## Engineers Comments Regarding Surface Water Drainage

<b>Application Reference:</b>	F/15/24/RES	<b>Reviewer Reference:</b>	ADC/SB
<b>Planning Officer:</b>	Jessica Riches	<b>Date of Review:</b>	30/07/2025
<b>Site Name:</b>	Land at Ford Airfield Ford		
<b>Application Description:</b>	Approval of reserved matters (layout, scale, appearance and landscaping) following outline permission F/4/20/OUT for phase RM1 (North), for the erection of 341 No. residential dwellings plus associated roads, infrastructure, parking, landscaping and associated works. This application affects a Public Right of Way, may affect the setting of a Listed Building and falls within CIL Zone 1 (Ford strategic site - zero rated).		
<b>Assessment Number:</b>	2 of 1

**From:** Sarah Burrow <Sarah.Burrow@arun.gov.uk>  
**Sent:** 30 July 2025 14:56  
**To:** Planning.Responses <Planning.Responses@arun.gov.uk>  
**Cc:** Karl McLaughlin <Karl.McLaughlin@arun.gov.uk>; Paul Cann <Paul.Cann@arun.gov.uk>; Jessica Riches <Jessica.Riches@arun.gov.uk>; Neil Crowther <Neil.Crowther@arun.gov.uk>; David Easton <David.Easton@arun.gov.uk>  
**Subject:** F/15/24/RES - Ford Airfield RM1 ADC Drainage Consultation 2

Drawing Title: RM1 - LEVELS STRATEGY (SHEET 1)

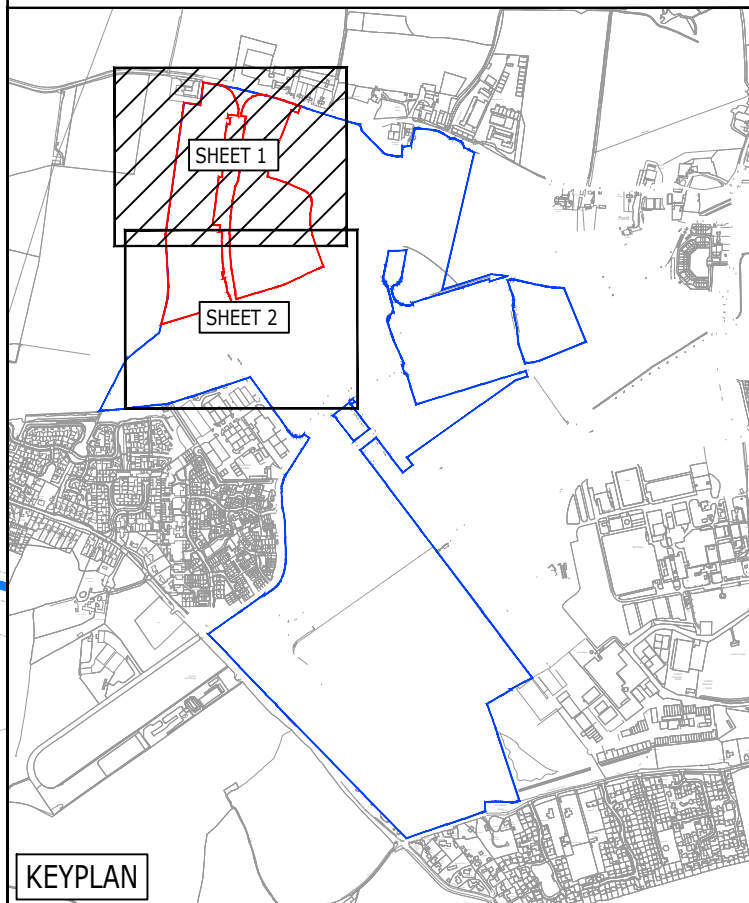
#### **Ground Raising**

There are significant alterations to the ground levels proposed as part of the delivery of the site and the surface water drainage design. The impact and extent of the ground level changes are not discussed within the DTN.
